MECKLENBURG COUNTY
Land Use & Environmental Services Agency

MEMORANDUM

To: Charlotte-Mecklenburg Planning Commission
From: LUESA, Mecklenburg County
Date: 7.27.23
Subject: Rezoning Petition Comments

2023-036: 11128 Mallard Creek Road

EXISTING CONDITIONS PLAN

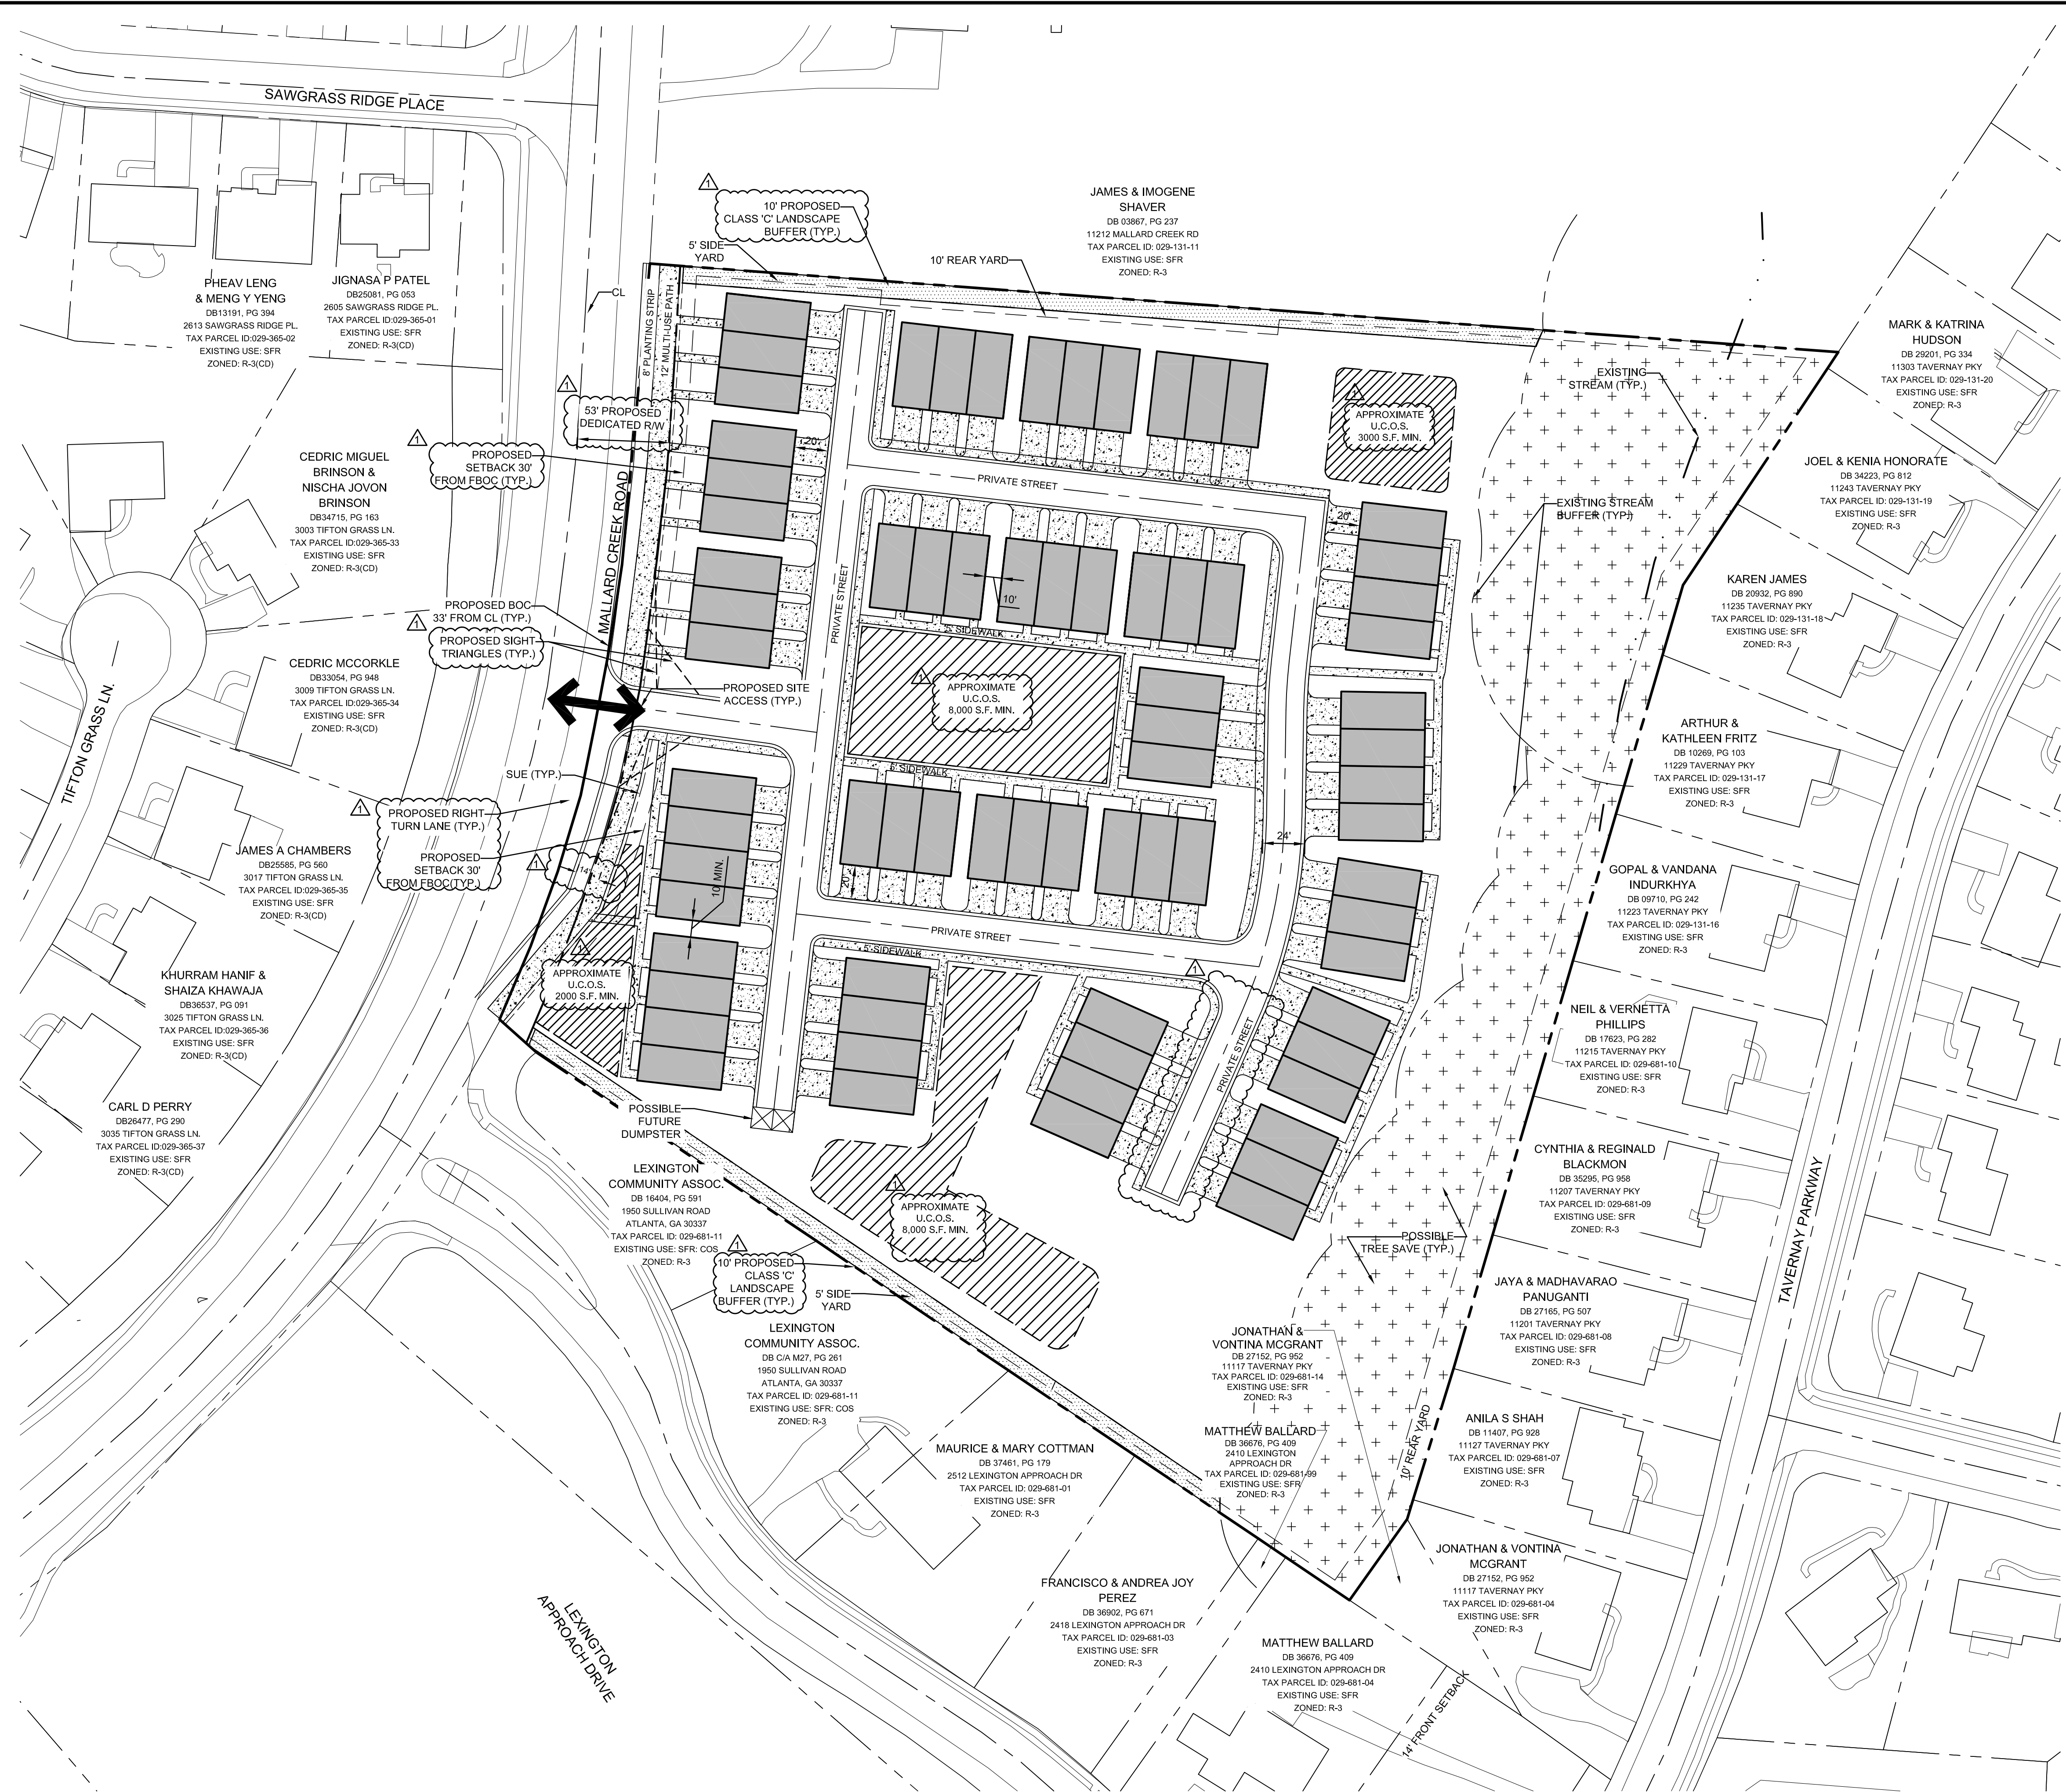
Air Quality Comments: Demolition or renovation of existing structures may require proper notification and removal of asbestos. A letter of notification and the required forms have been mailed directly to the petitioner.

Ground Water Services Comments: Groundwater & Wastewater Services (GWS) records indicate that a water supply well has been registered and located within the bounds of parcel 029-131-10. Water supply wells should be protected during site development by flagging and fencing or be permanently abandoned in accordance with the Mecklenburg County Groundwater Well Regulations prior to site development commencing.
